October 17, 2019

Subject: **Request for Modification to Individual Section 404 and Section 401 Water Quality Certification** for the Winston-Salem Northern Beltway from US 52 to US 311 (New Walkertown Road), Forsyth County. Federal Aid Project No. NHP-0074(213), TIP Nos. U-2579D, E& F. Division 9.

### **Permit Impact Site Modifications**

REVISIONS

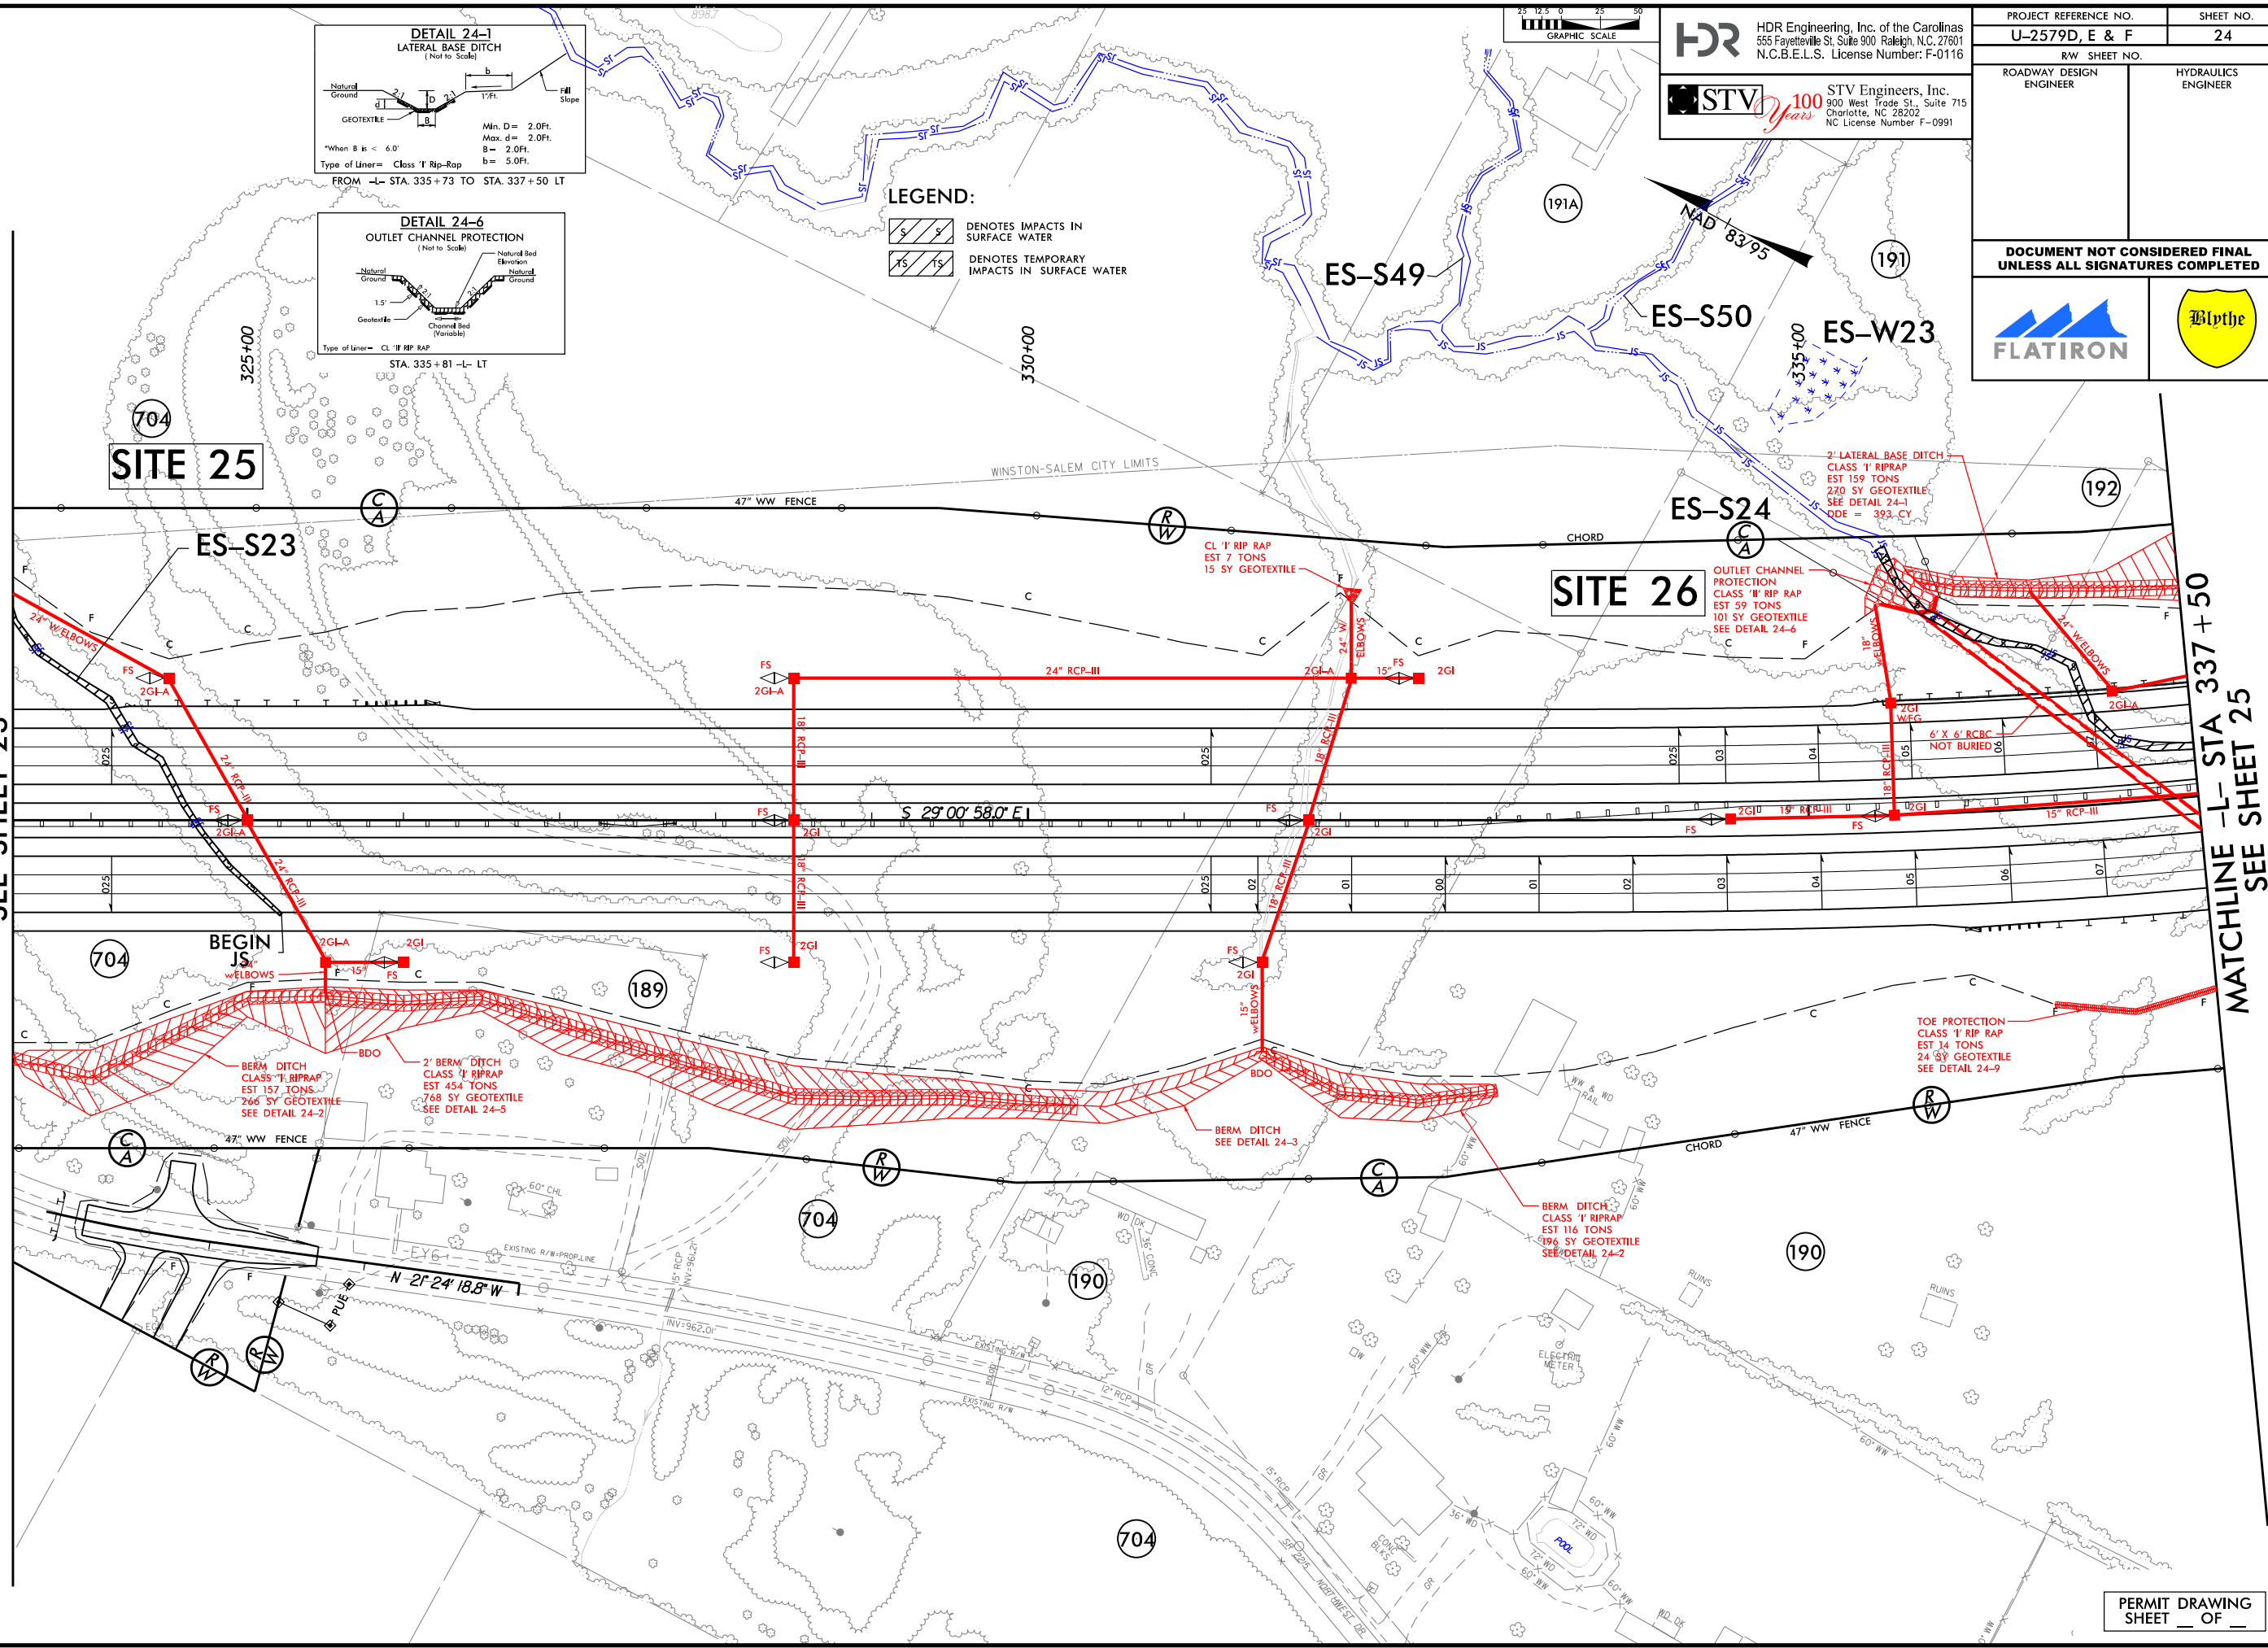
Site 23 (Sheet 23): Site 23 impacts changed as a result of the final design of the 6x6 RCBC in which the culvert length was increased from preliminary plans. When reviewed with the previous modification the new culvert length resulted an increase in permanent impacts by 15 linear feet for the RCBC and by 2 linear feet for bank stabilization. The temporary impact at this site was reduced by 11 linear feet. There will be a total of 363 linear feet of impact due to the RCBC, 28 linear feet of bank stabilization, and 10 linear feet of temporary stream impact at Site 23.

MATCHLINE -L- STA 323+50
 SEE SHEET 23

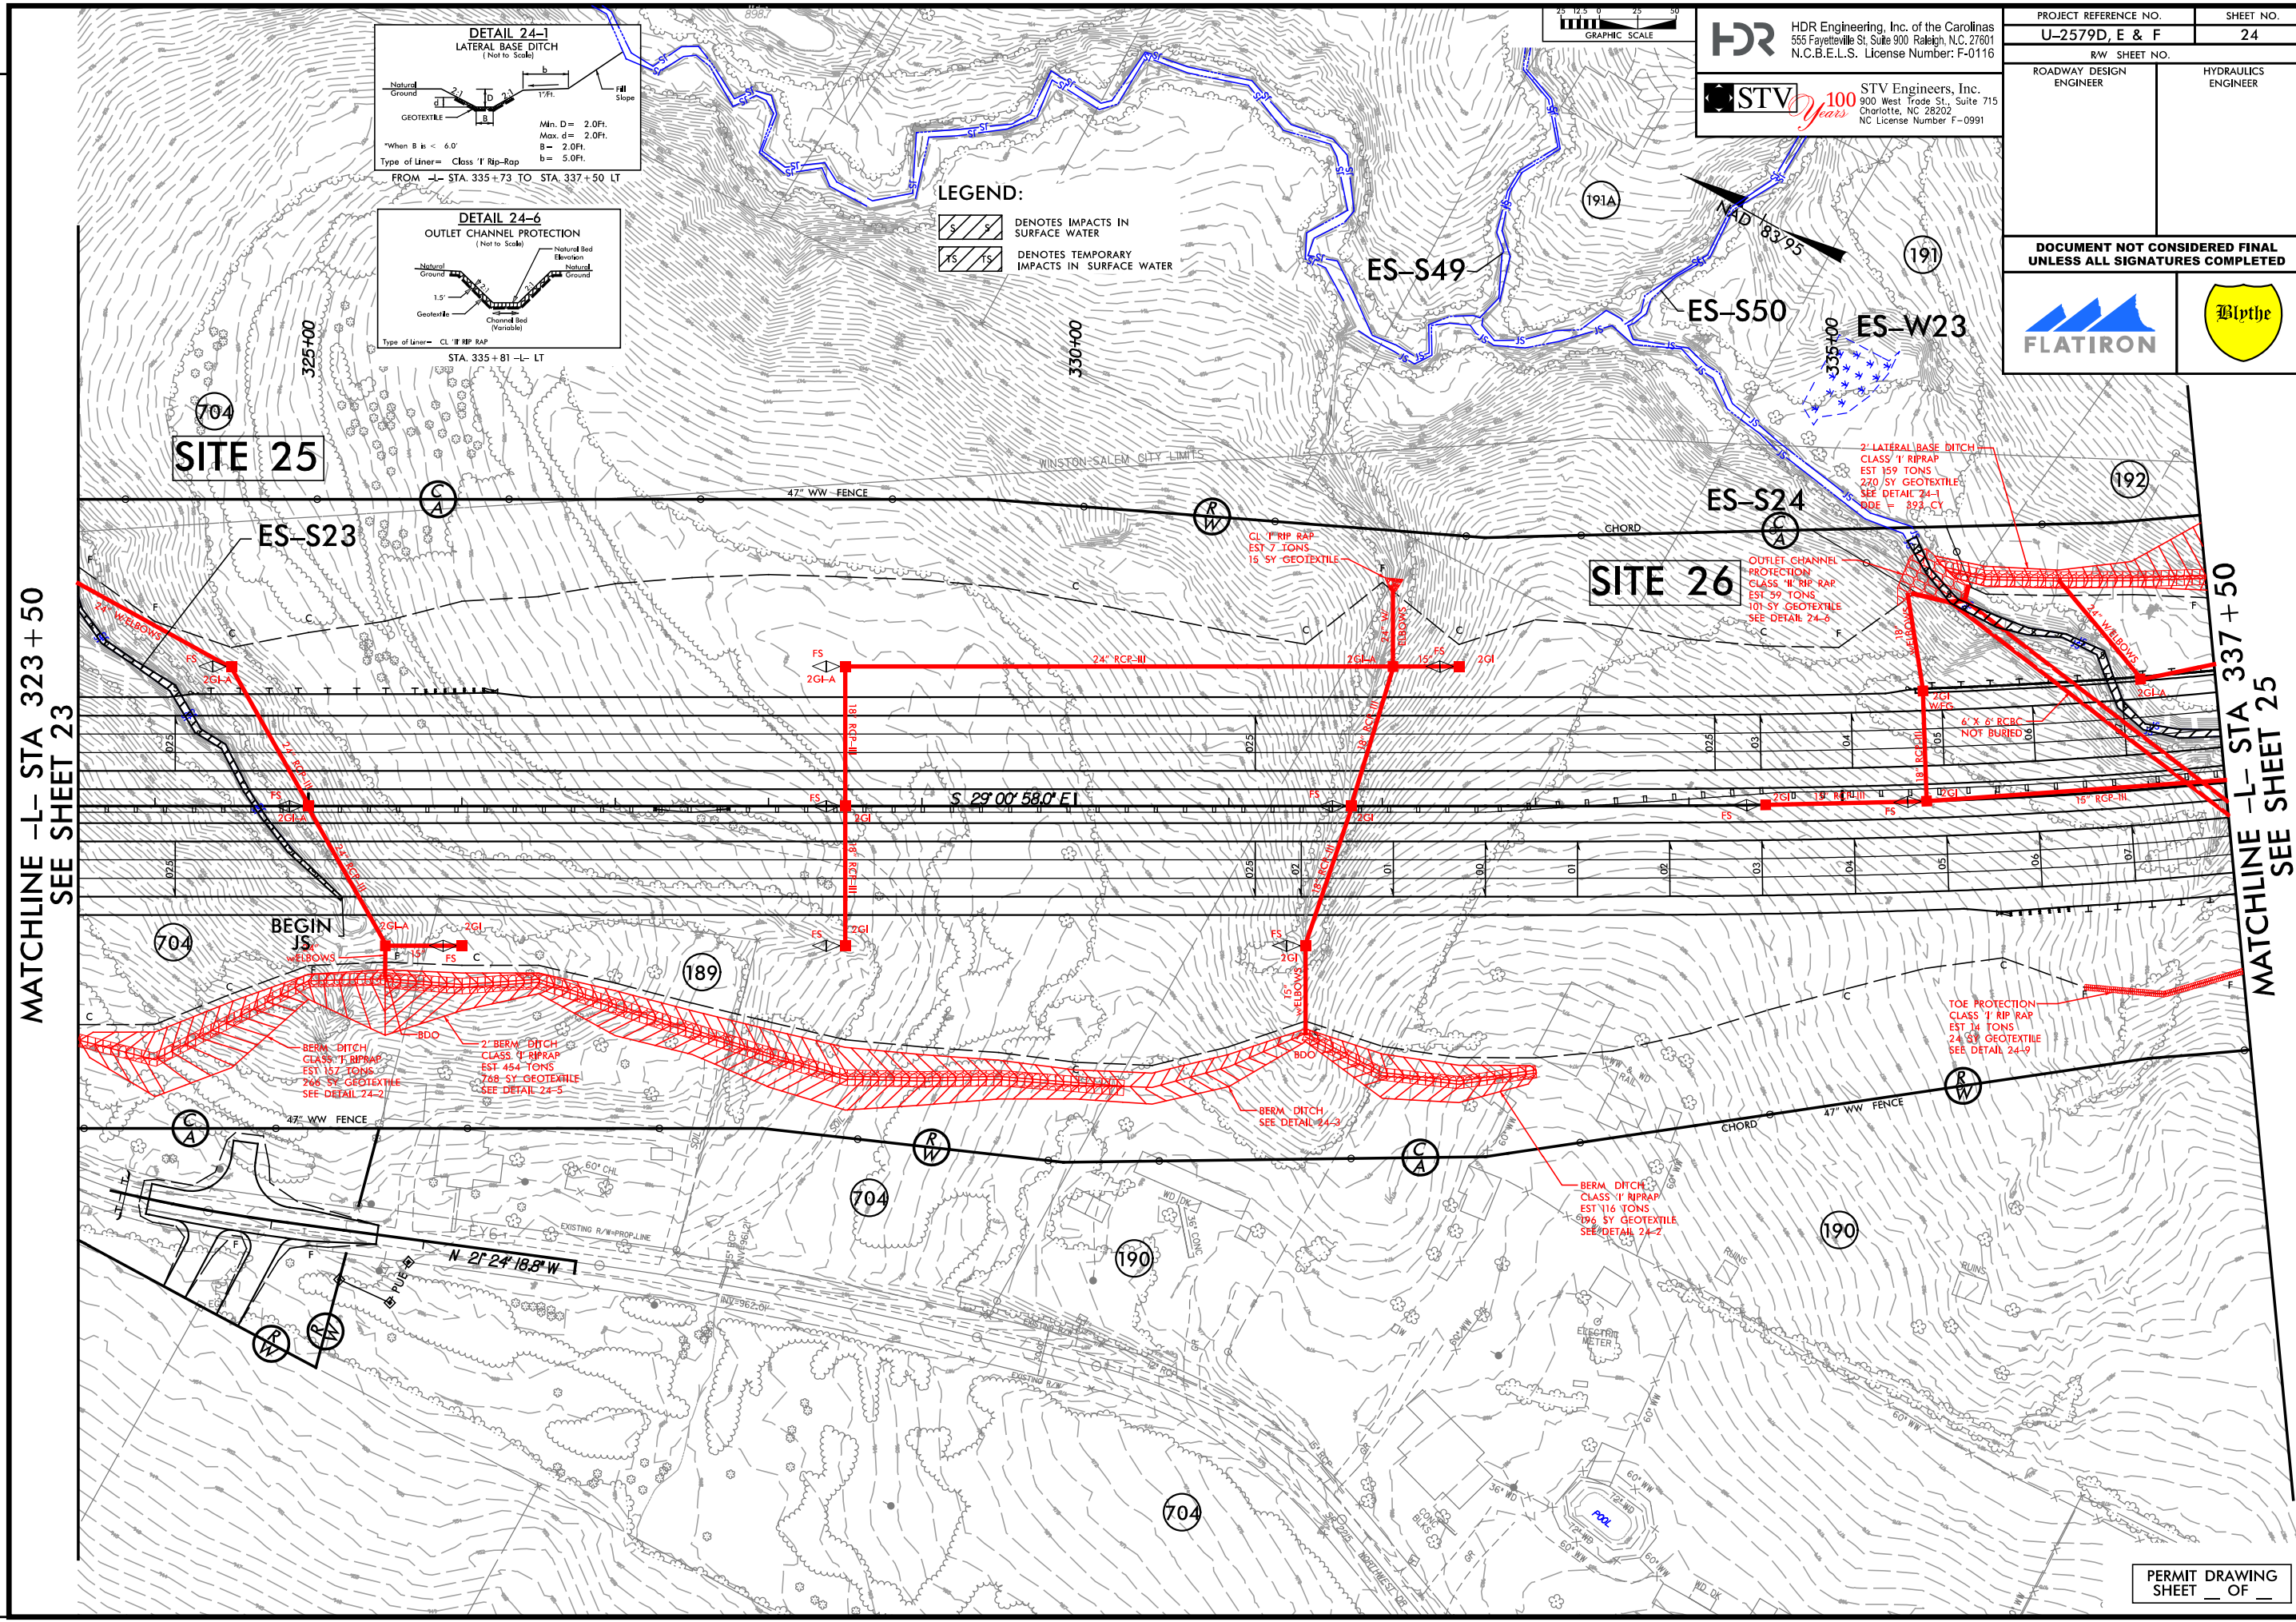
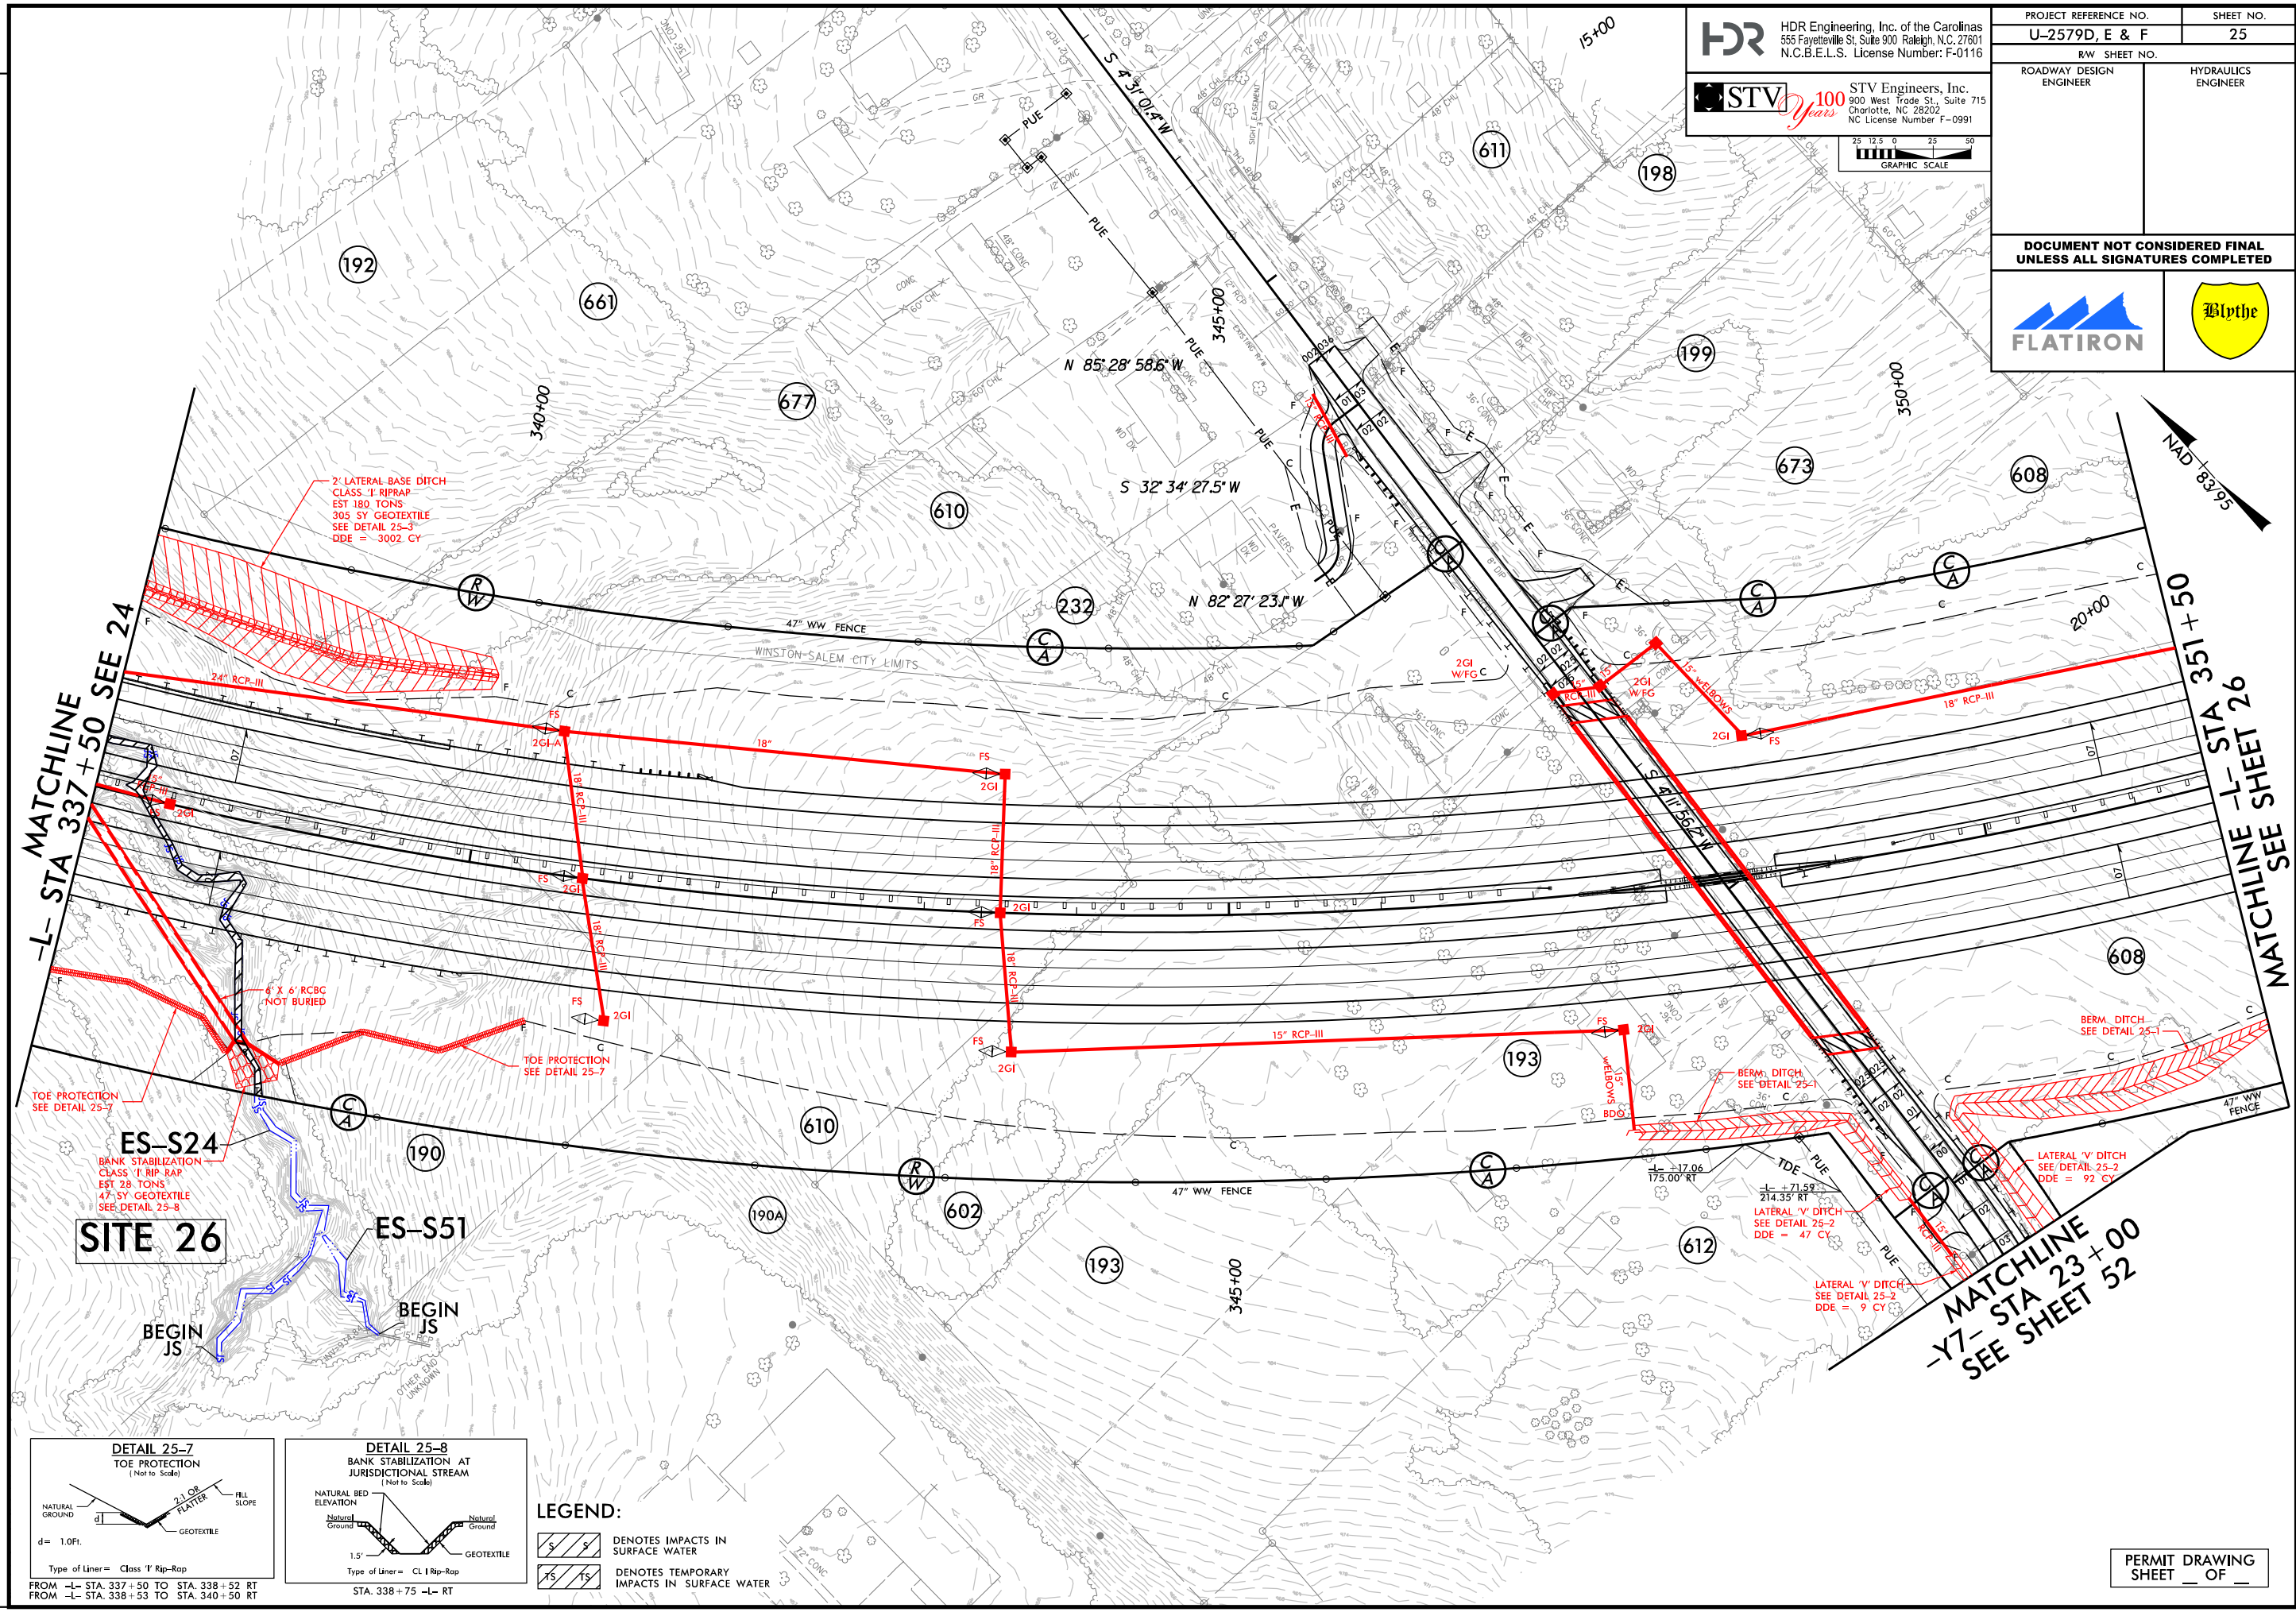
Site 26 (Sheets 24 and 25): Site 26 impacts changed as a result of the final design of the 6x6 RCBC in which the culvert length was increased from preliminary plans. When reviewed with the previous modification the new culvert length resulted an increase in permanent impacts by 4 linear feet for the RCBC and by 5 linear feet for bank stabilization. The temporary impact at this site was reduced by 2 linear feet. There will be a total of 523 linear feet of impact due to the RCBC, 29 linear feet of bank stabilization, and 18 linear feet of temporary stream impact at Site 26.
